Our Ref: BR/25/21/DOC

Town & Country Planning Act 1990 (as amended)
Town and Country Planning (Development Management Procedure) (England) Order 2015
Approval of details reserved by condition imposed under ref BR/257/19/PL relating to Condition No 4 -
balcony railings (height, finish, manufacturer/model name)
The Royal Hotel The Esplanade Bognor Regis PO21 1SZ

Arun District Council have decided to **APPROVE details reserved by this condition**

DRAWING NO.	REVISION
169 / 4.210	01

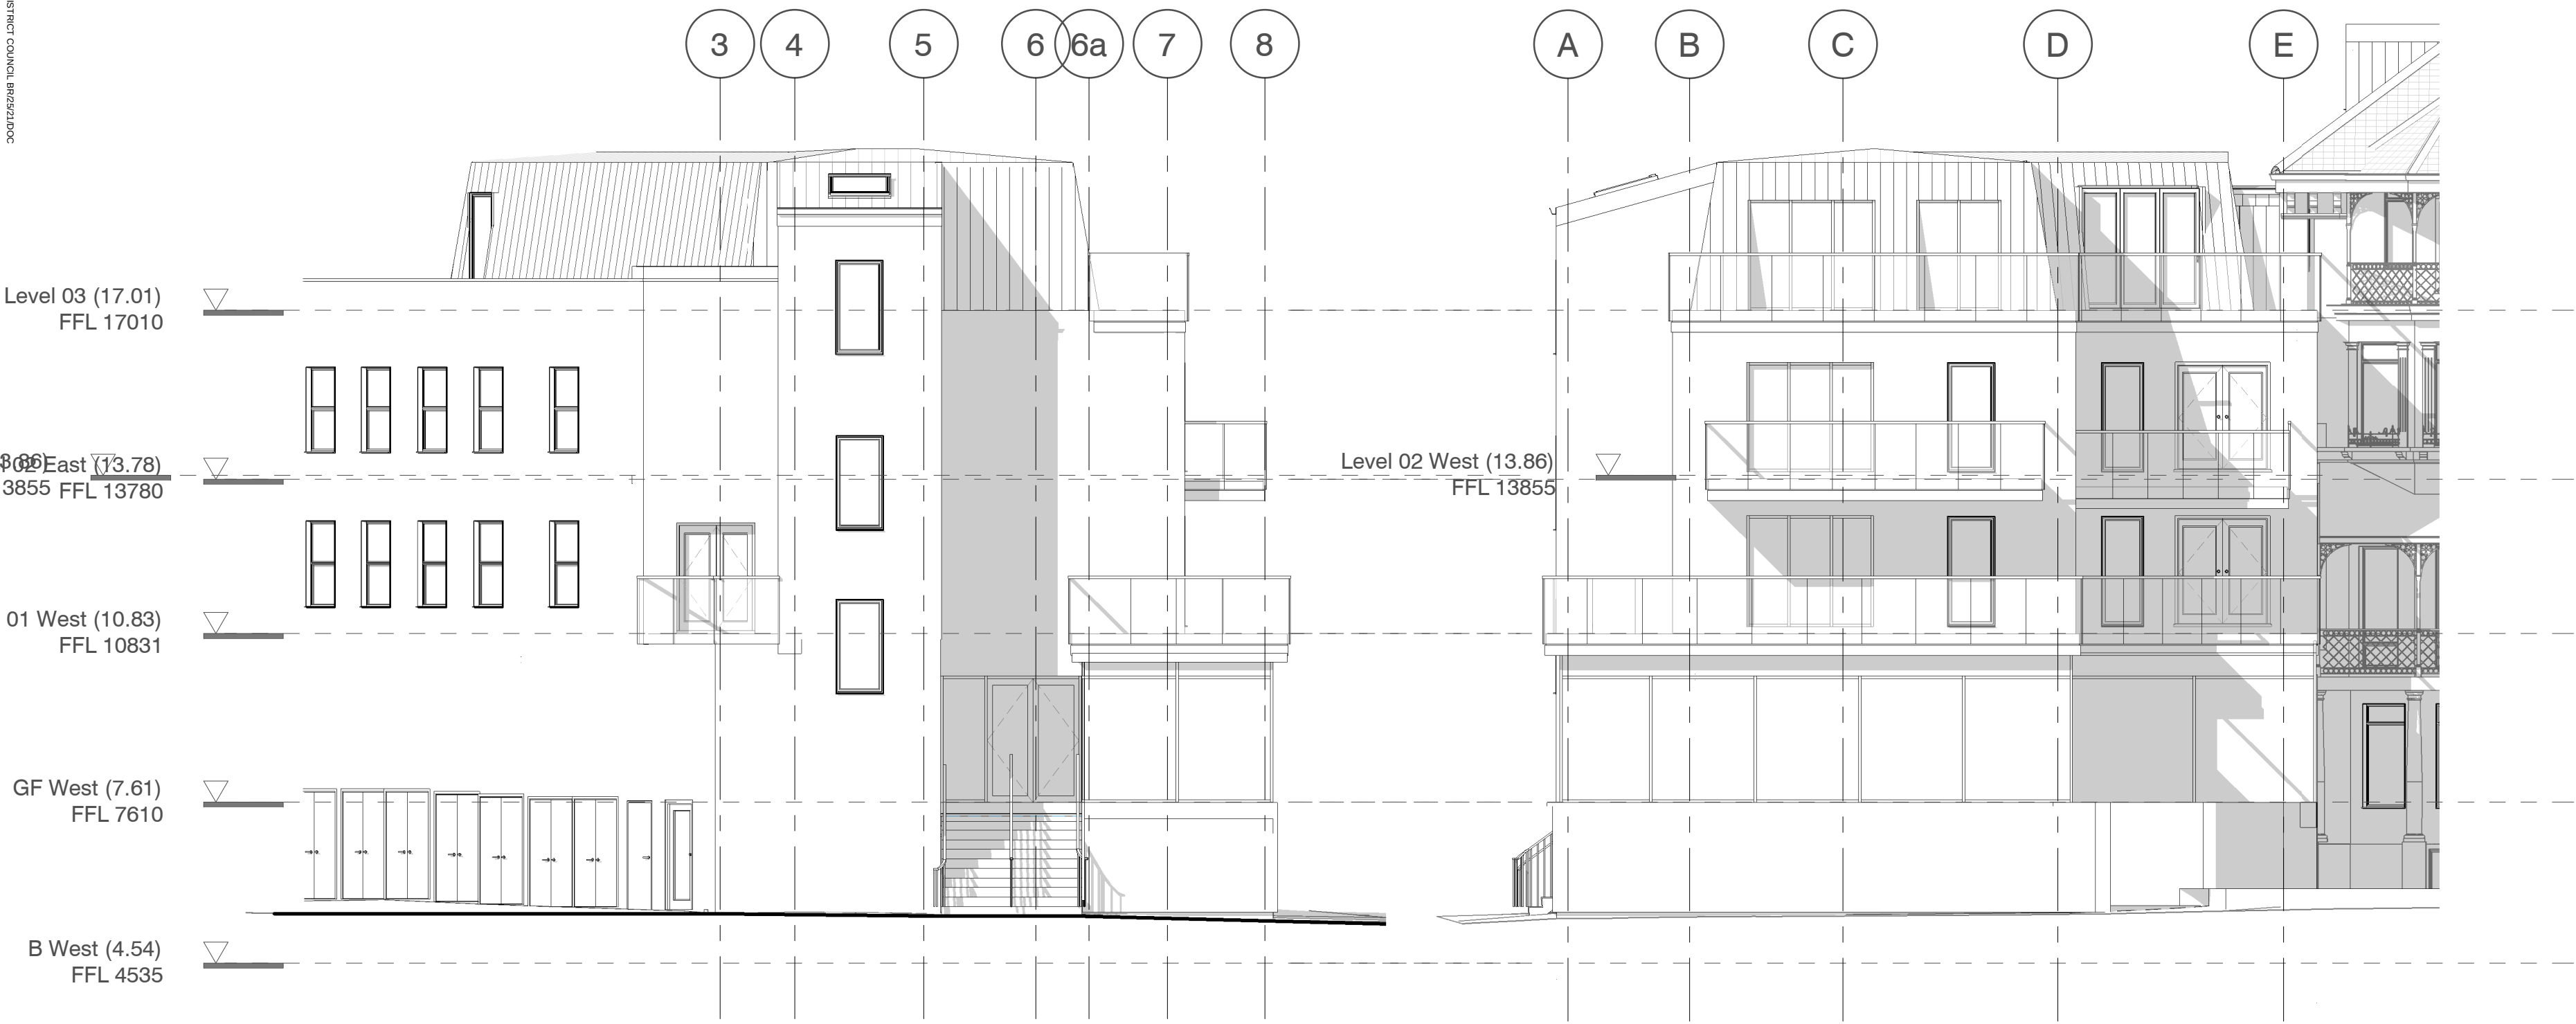
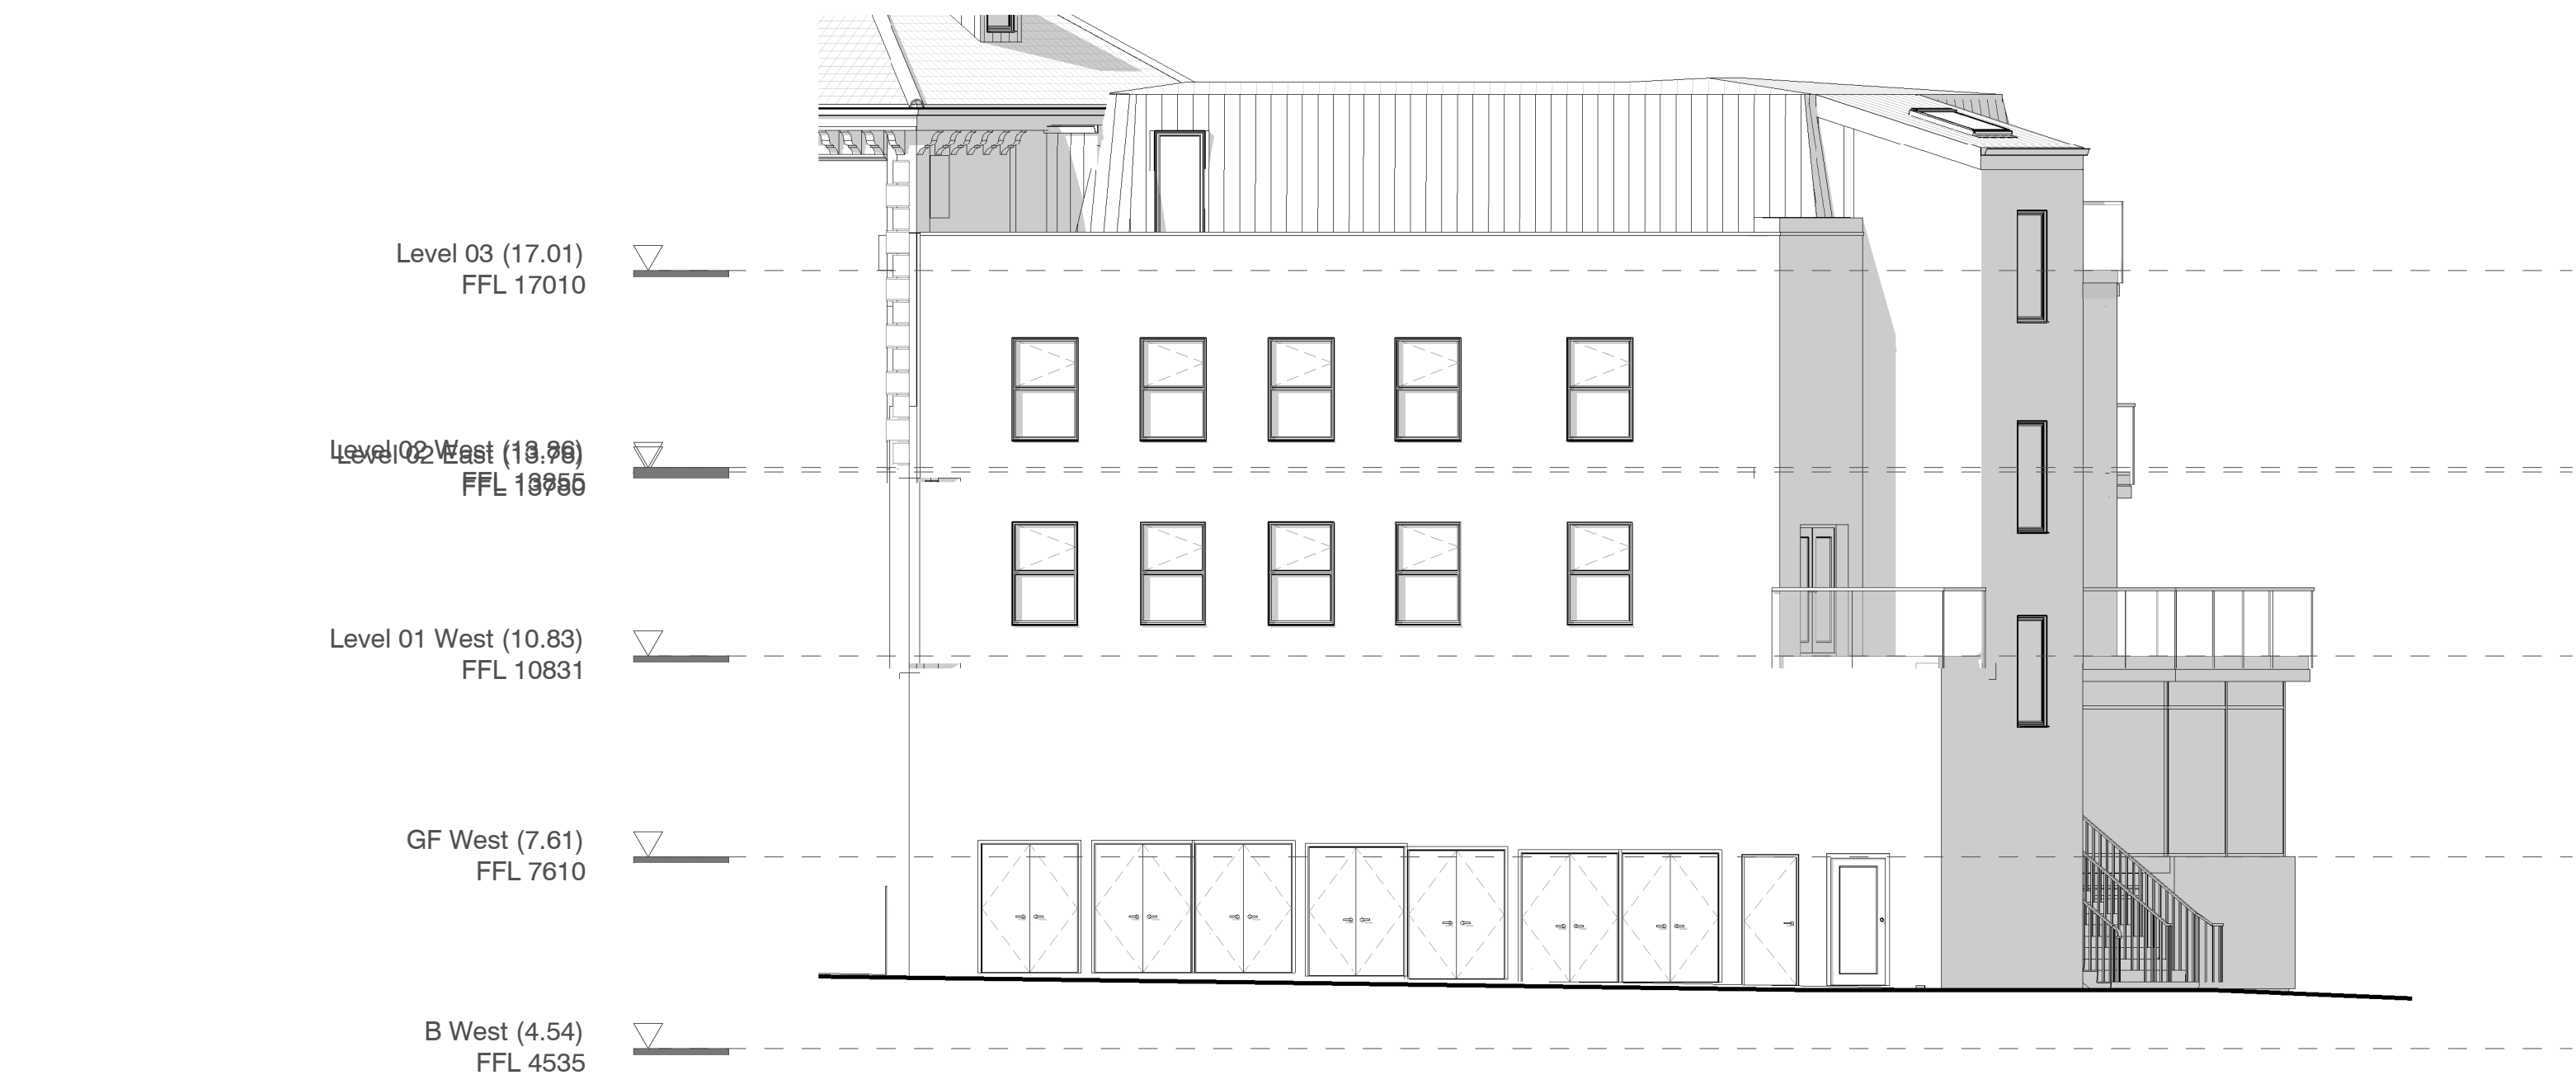
Type 1 - New Glazed, proposed height 1100mm, Bespoke glazing to architectural details; Detail 4, sheet 4.585, drawing 169/4.210 Rev 01.
